13-K-17

2006-0214

135 Sheridan Street  
Sheridan Heights  
Sheridan St., LLC.

**RE: 135 Sheridan Street; 21 Unit Condominiums**  
**Application ID Number: 2006-0214**  
**CBL 013 K002001Chart 116, Block E00, Lot 3001**

TITLE:
UTILITY PLAN
 SHERIDAN HEIGHTS
 121 & 135 SHERIDAN STREET
 PORTLAND, MAINE 04101

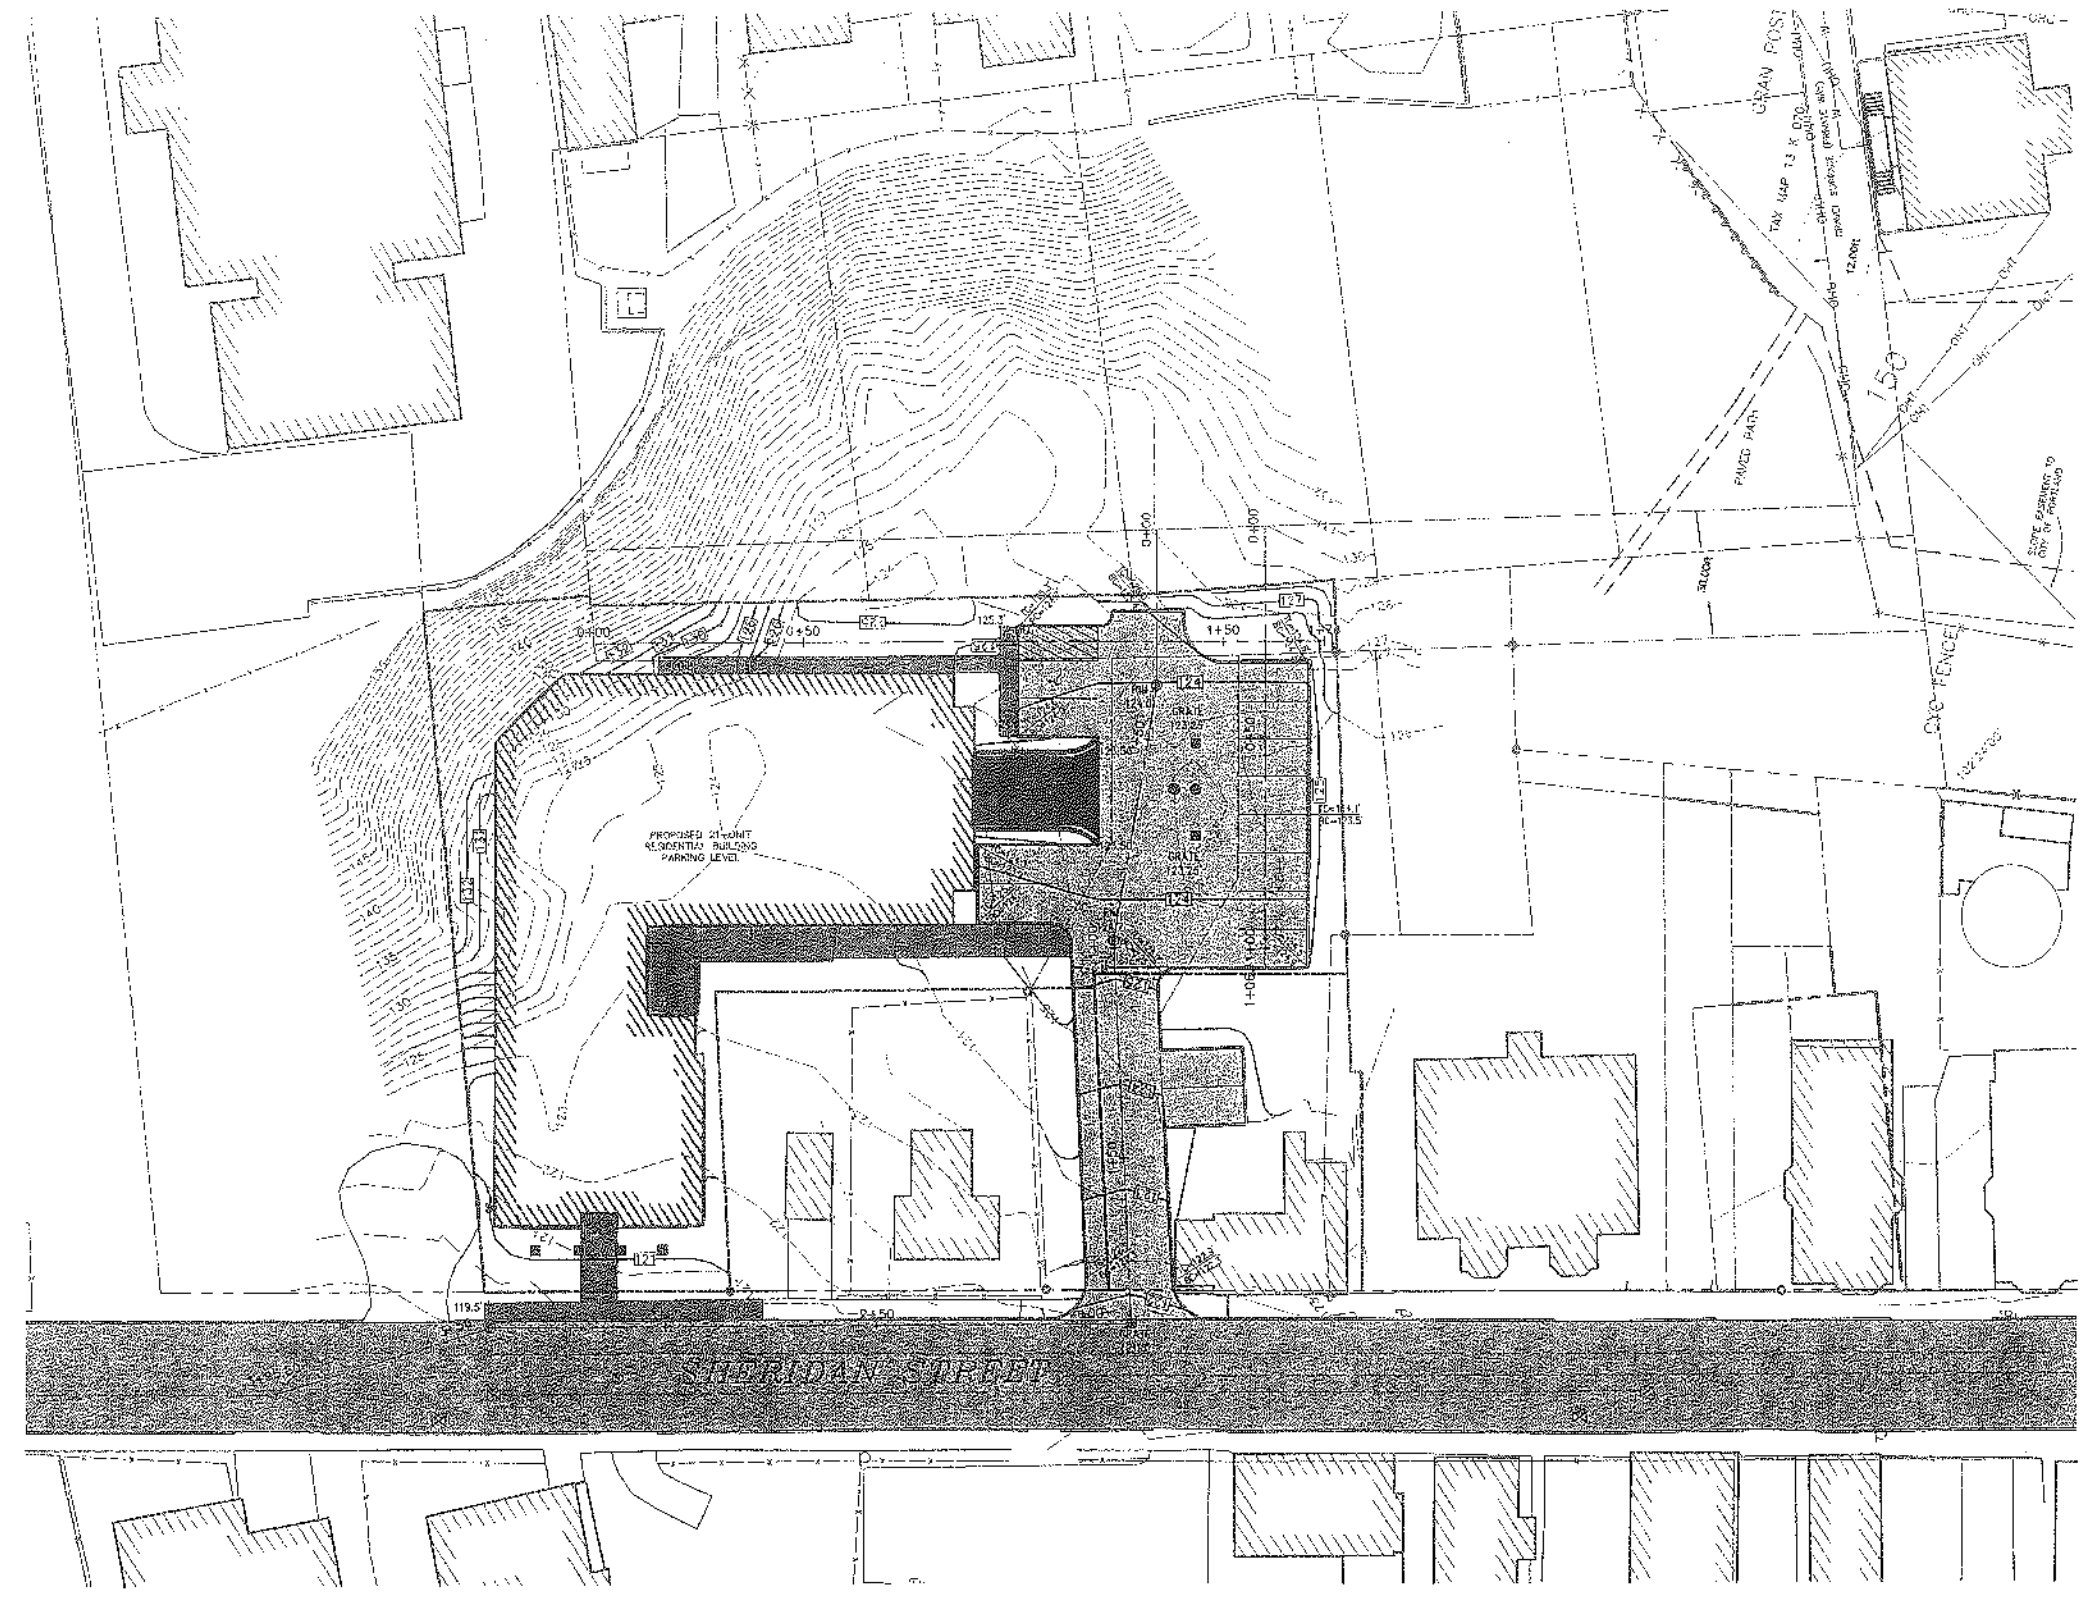
**There has been a change on the site plan; please replace the 'Utility Plan' sheet with this revised one. The project was approved on January 9, 2007.**

LANDSCAPE PLAN

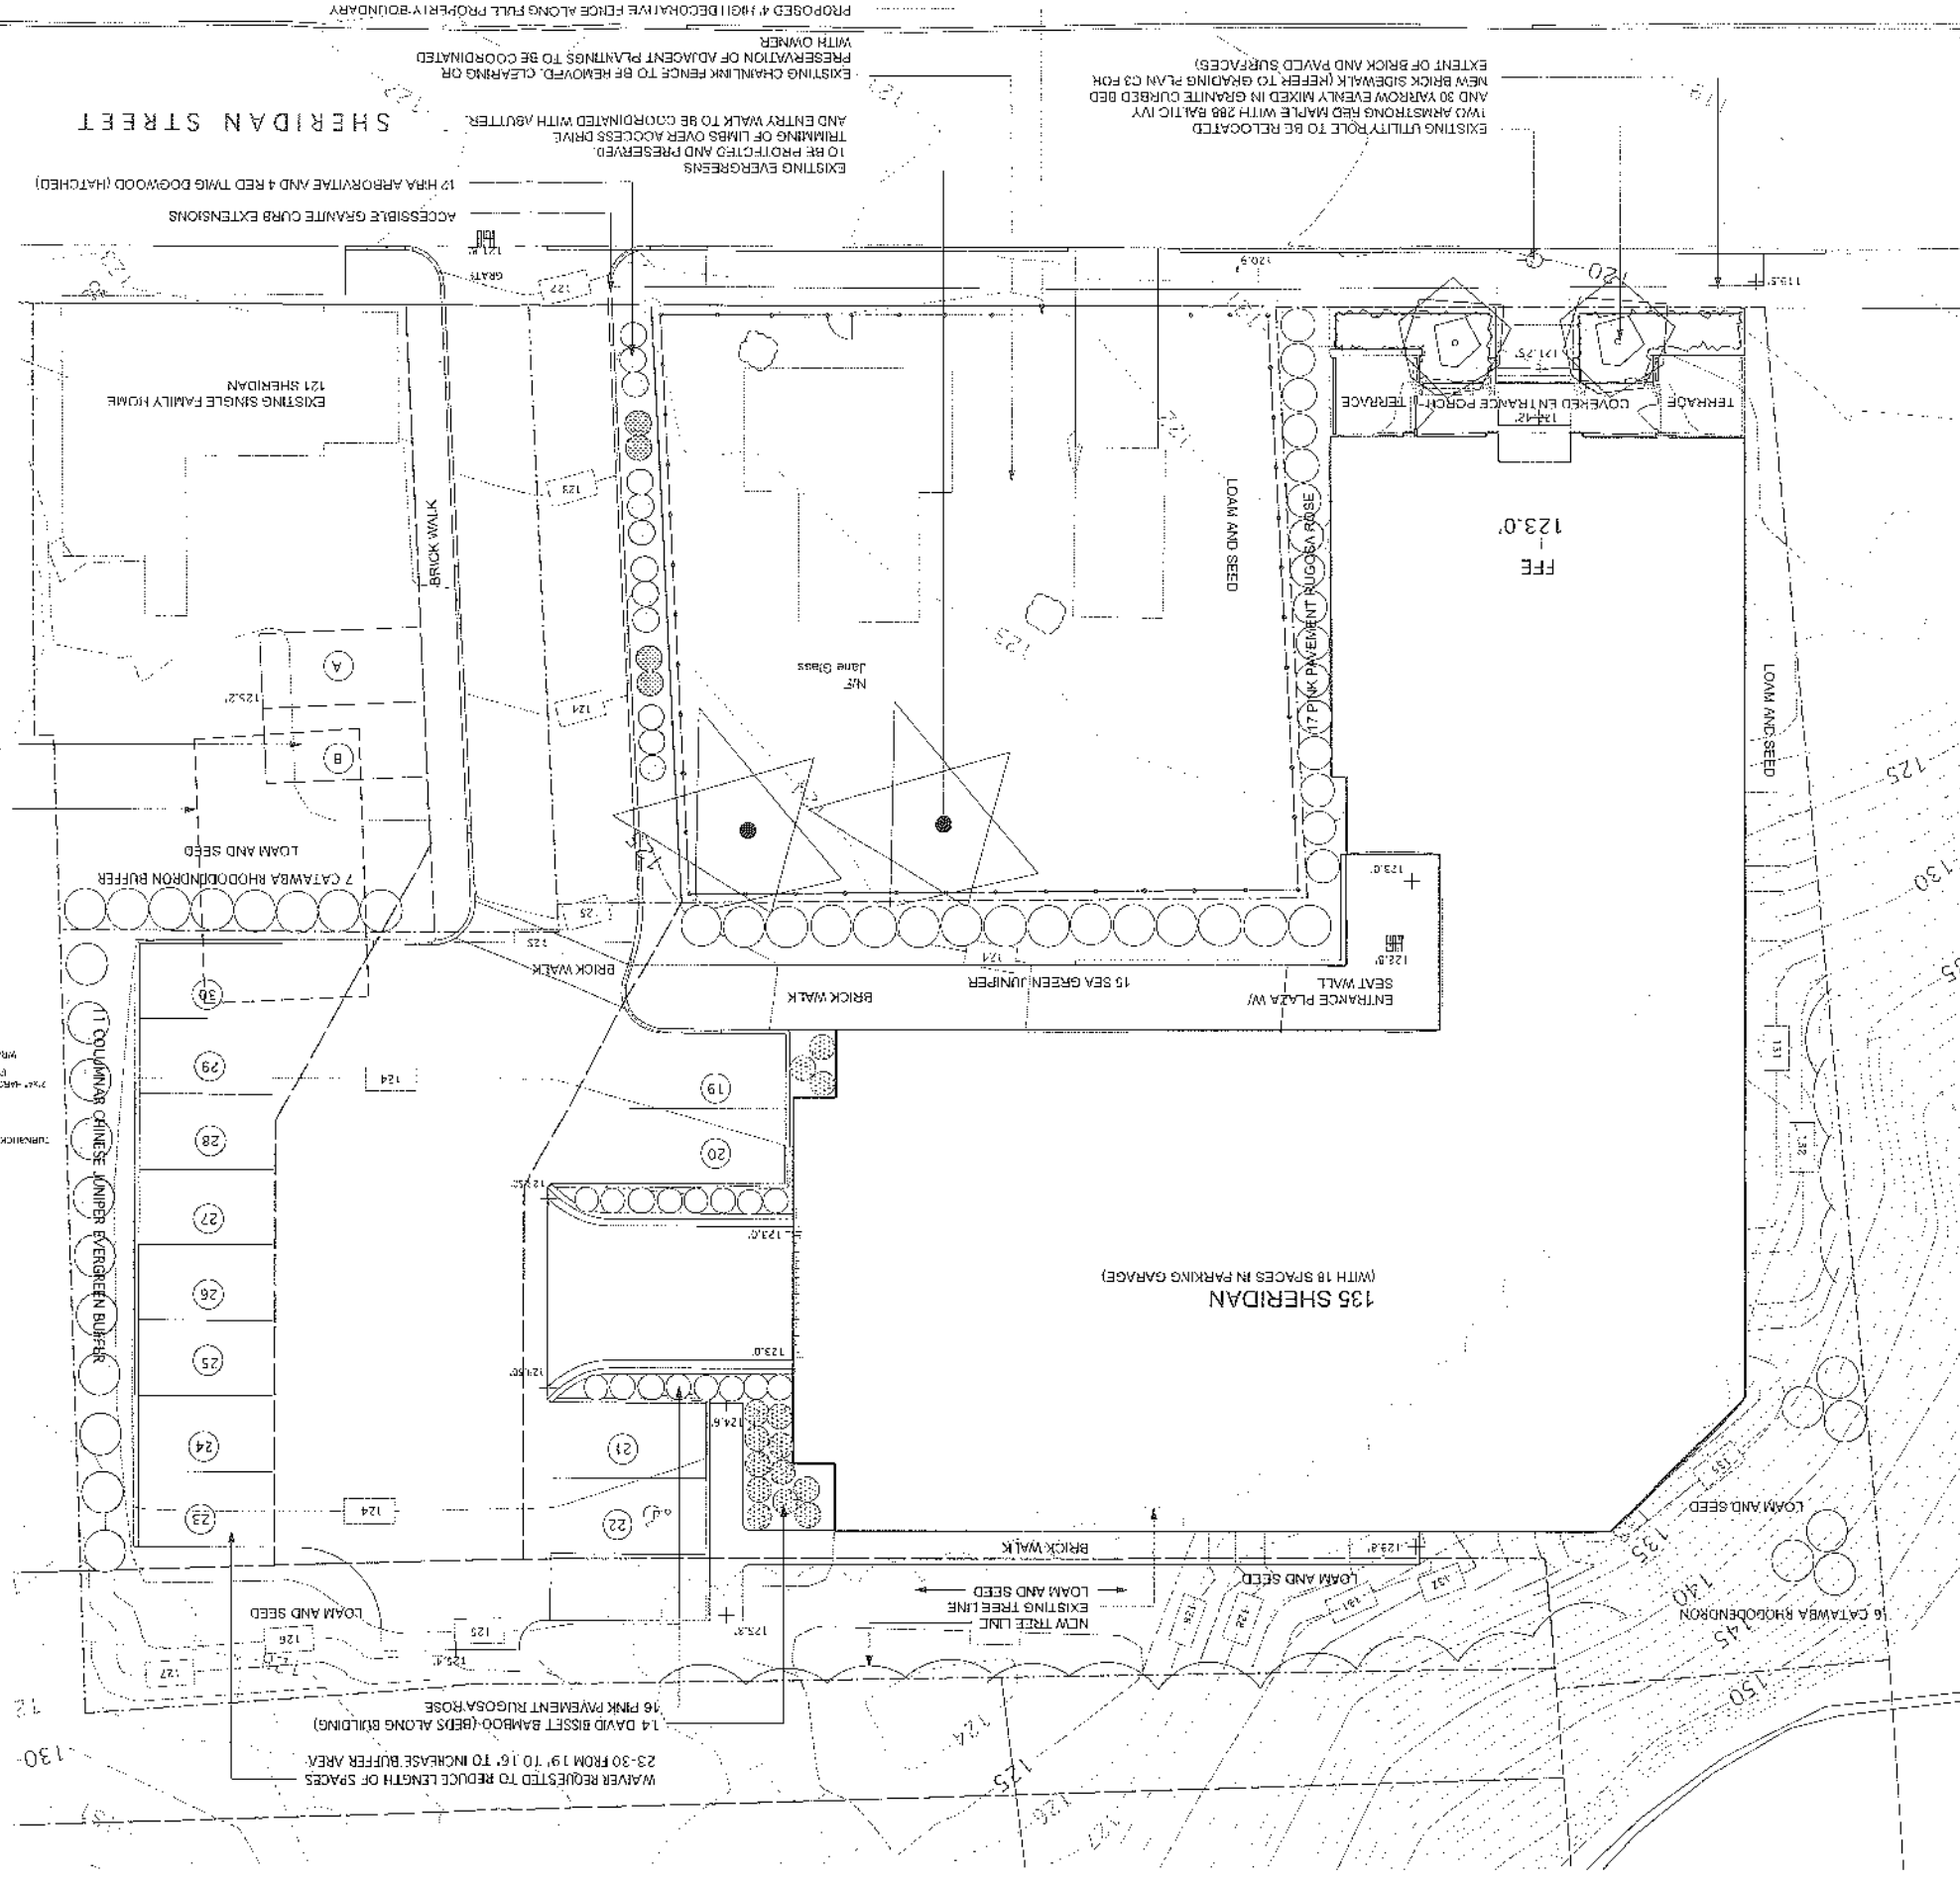
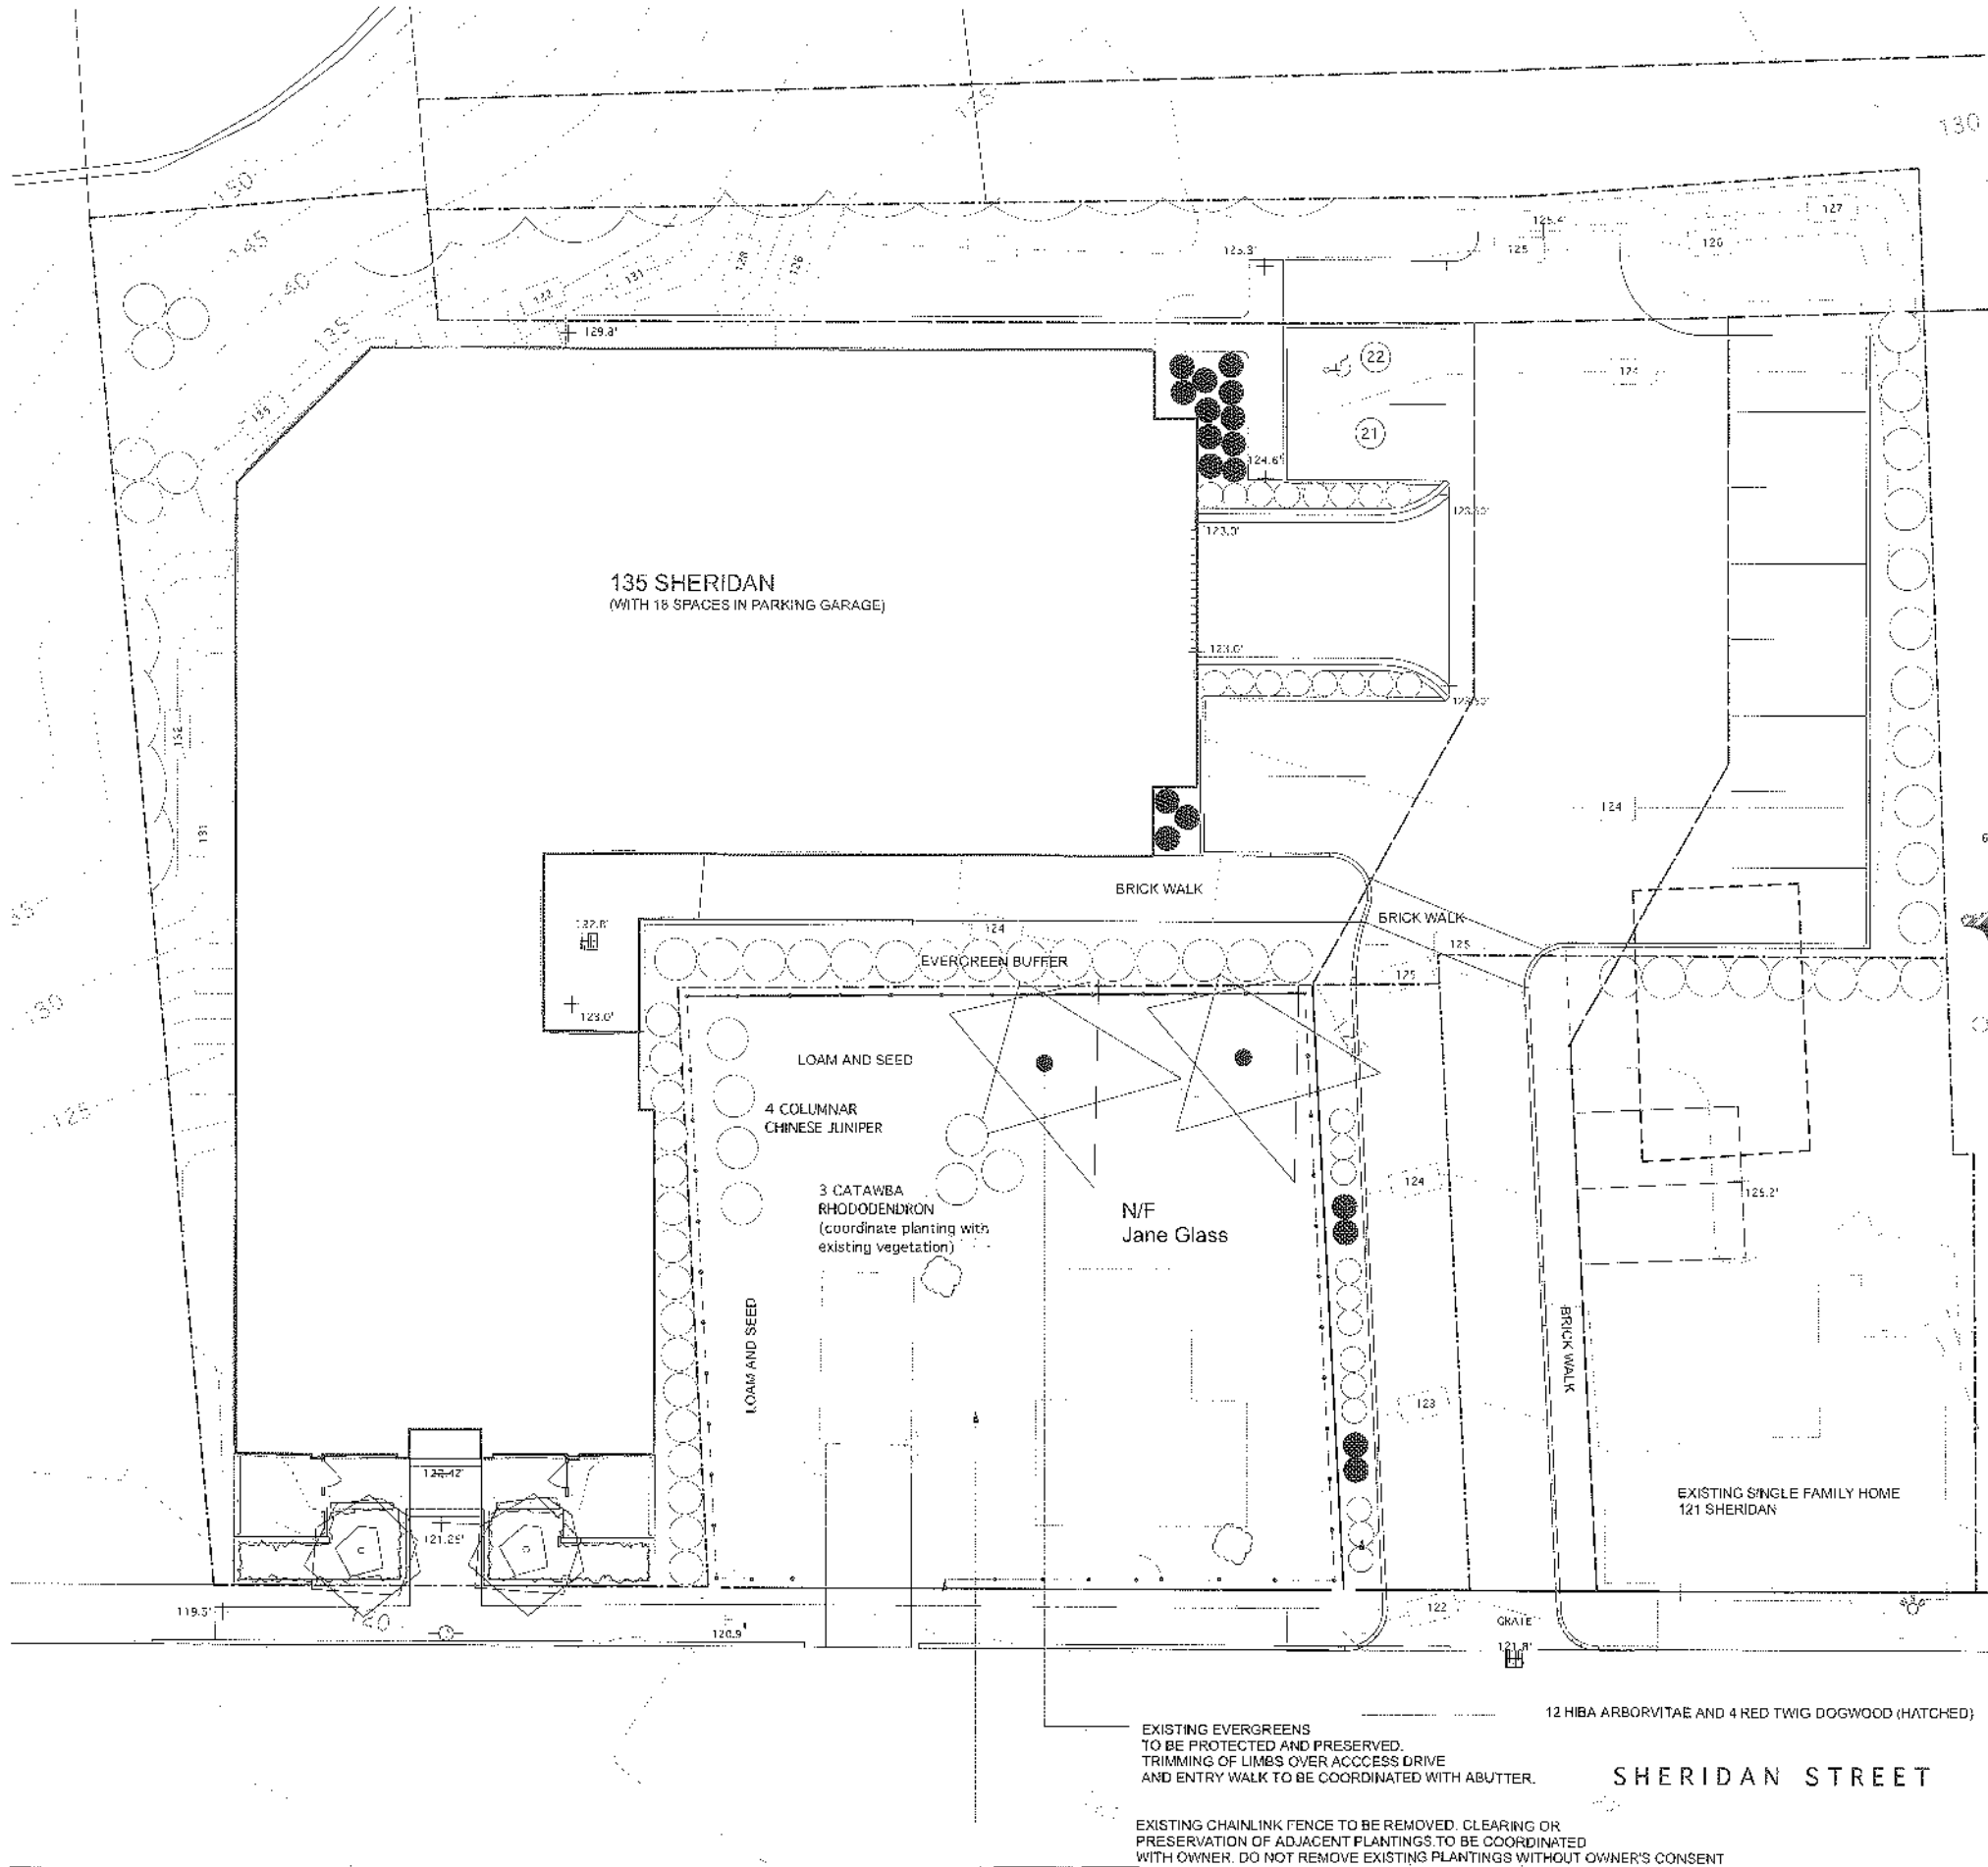
The purpose of this memo is to request approval for changes made to the approved Landscape Plans LG1 and L1SK1.

1. Moving the 4' tall fence on the south side of the 125 Sheridan Street parcel approximately 3 feet towards the south (towards the new driveway access for 135 Sheridan);
2. Adding a short retaining wall on the north side of the house located at 121 Sheridan Street to allow for the 20' tall red maple to remain and provide additional screening for the house.
